Lime Down

Solar Park

Supporting Environmental Information Report (Change Application)

Document Reference: EXAM/9.41

LIME DOWN SOLAR PARK
Figure 3-4-4.1
Lime Down Solar Park - Site D Sheet 1
Landscape and Ecology Mitigation Plan - Revision 4
END10168/APP/6.2
5(2)(a)

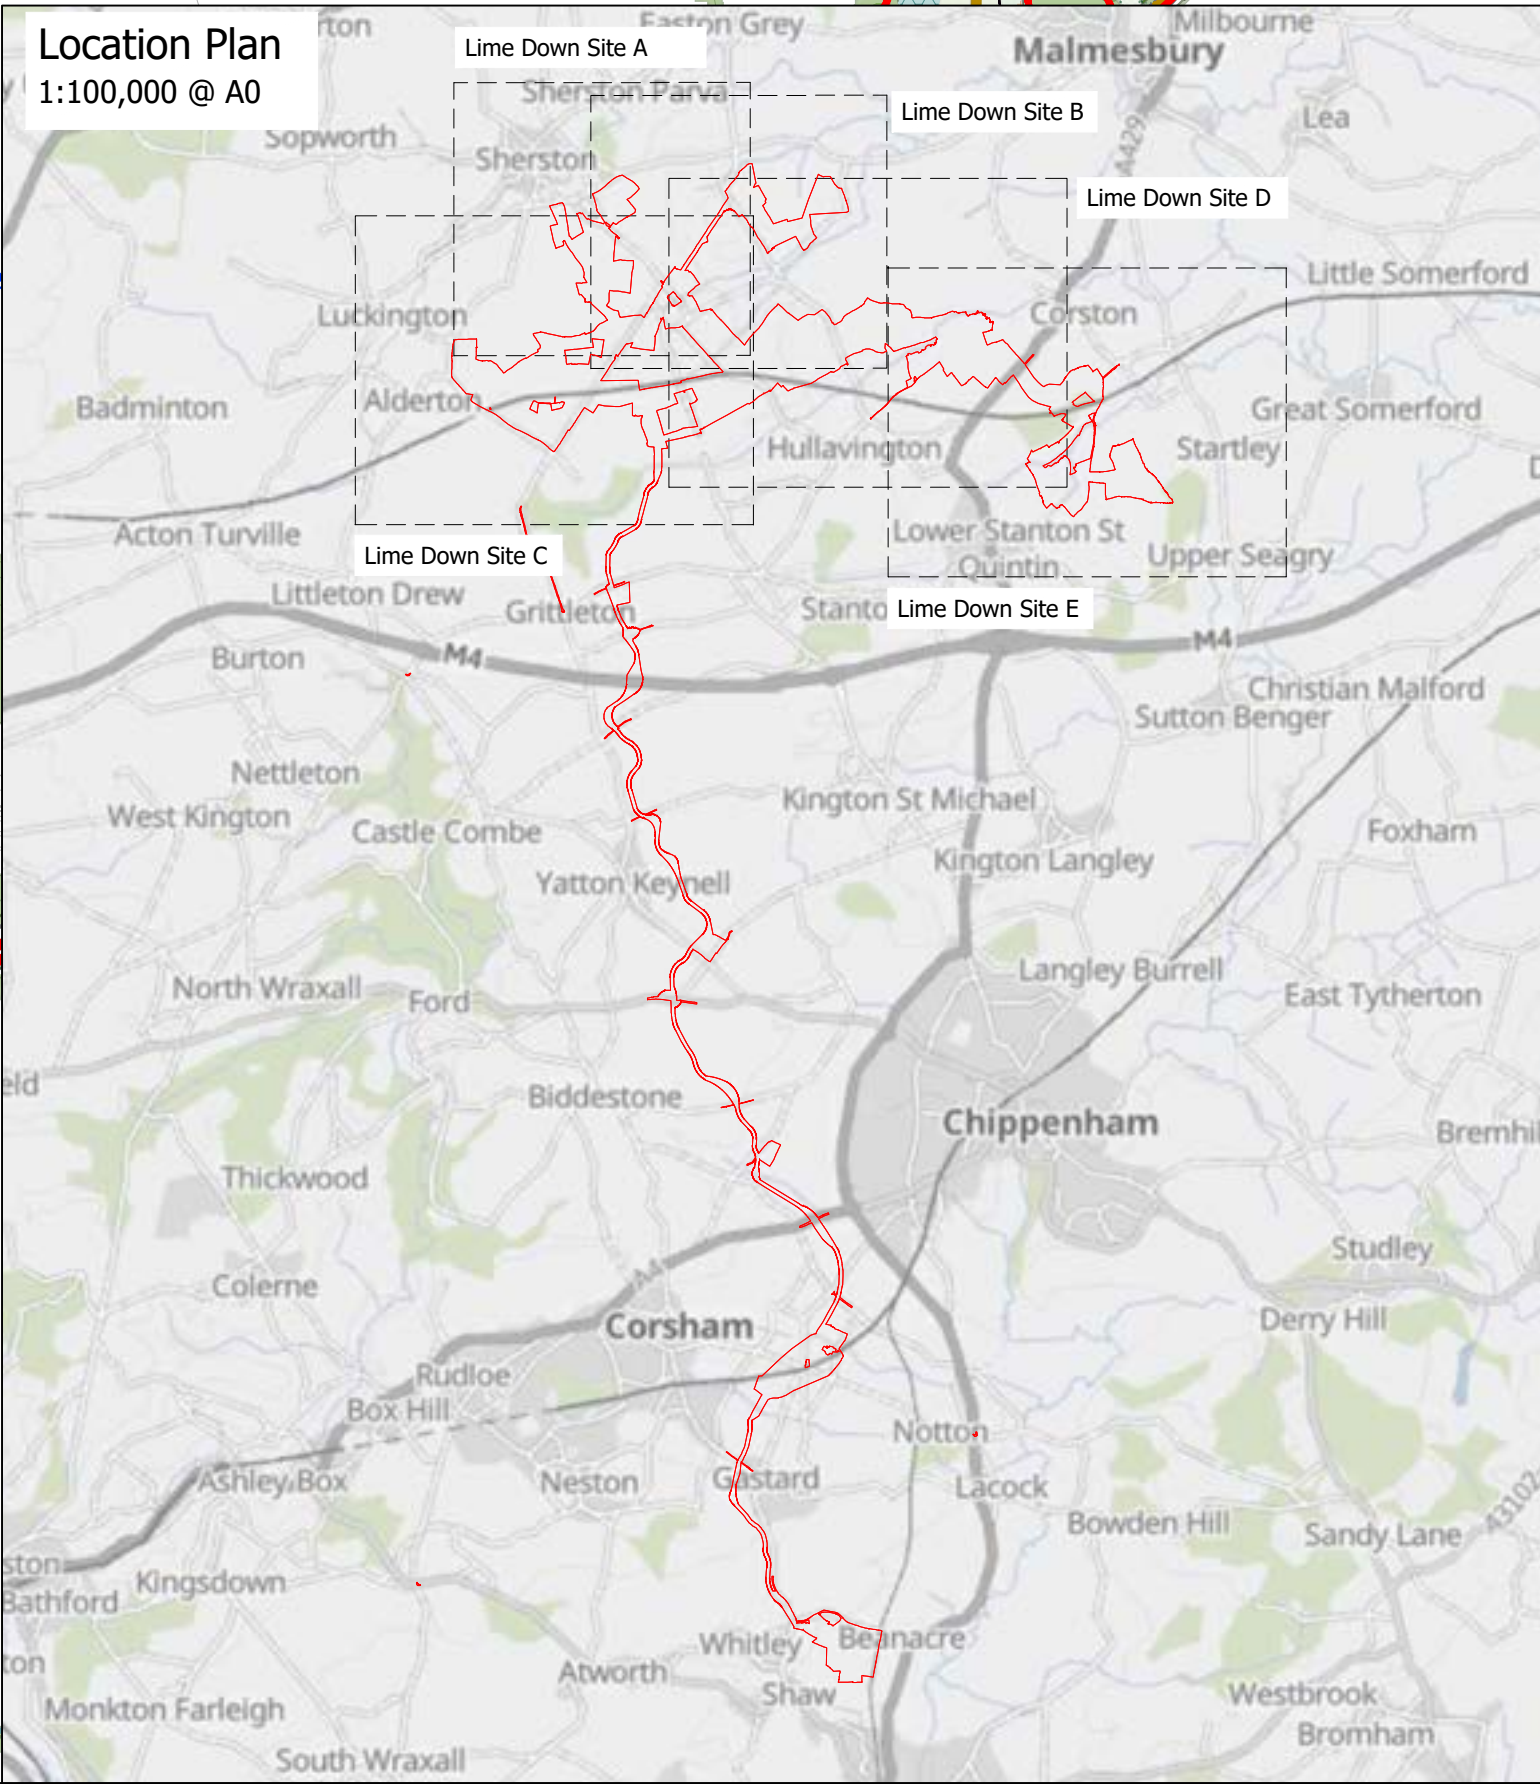
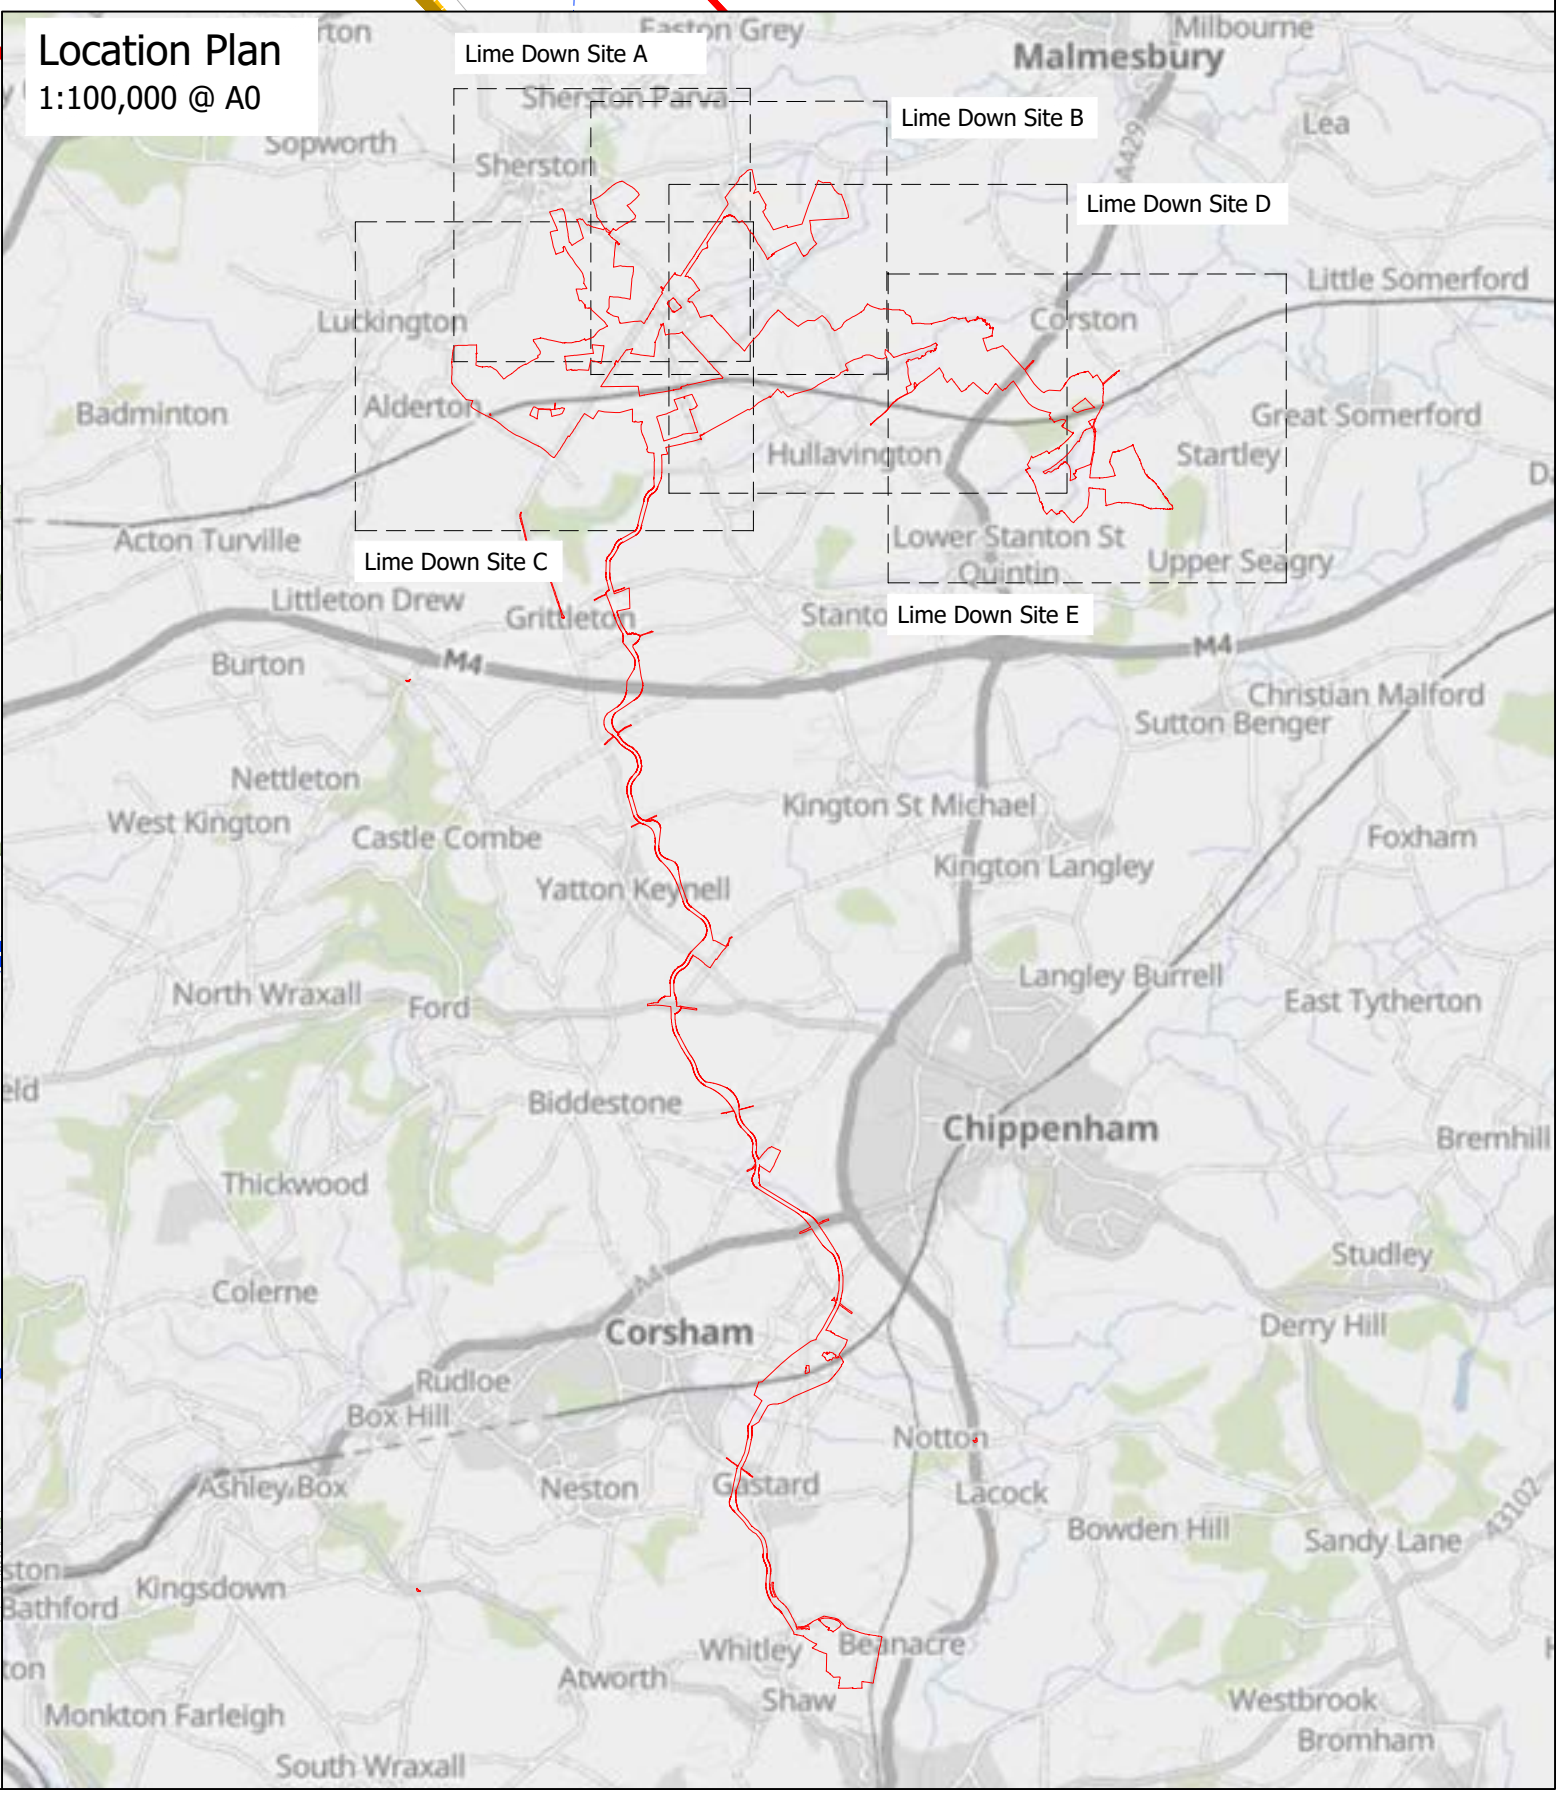
- 1.4.1 Change 1 comprises an extension to the Order Limits from the south western extent of the BESS emergency access (Access 21) at Lime Down D to the public highway named Hills Hayes Lane. A post-submission review by the Applicant of the Scheme accesses indicated that Access 21 did not adjoin the boundary of the public highway. This change will allow emergency Access 21 to tie into the public highway. The additional land will contain the bellmouth of emergency Access 21 which will comprise hardcore or gravel over a levelling layer of substrate. The **Outline Construction Traffic Management Plan [EN010168/APP/7.22 [Change Application]]** illustrates in Appendix A how emergency Access 21 ties into the public highway.

- 1.10.2 The changes have been reviewed and are not considered to give rise to any changes to the construction phase, operation phase and decommissioning phase assessment outcomes. The effects reported in **ES Volume 1, Chapter 8: Landscape and Visual [APP-060]** remain unchanged.
- 1.10.3 **ES Volume 2, Figure 3-4-4 Landscape and Ecology Mitigation Plan, Site D [EN010168/APP/6.2 [Change Application]]** has been updated to reflect this change.
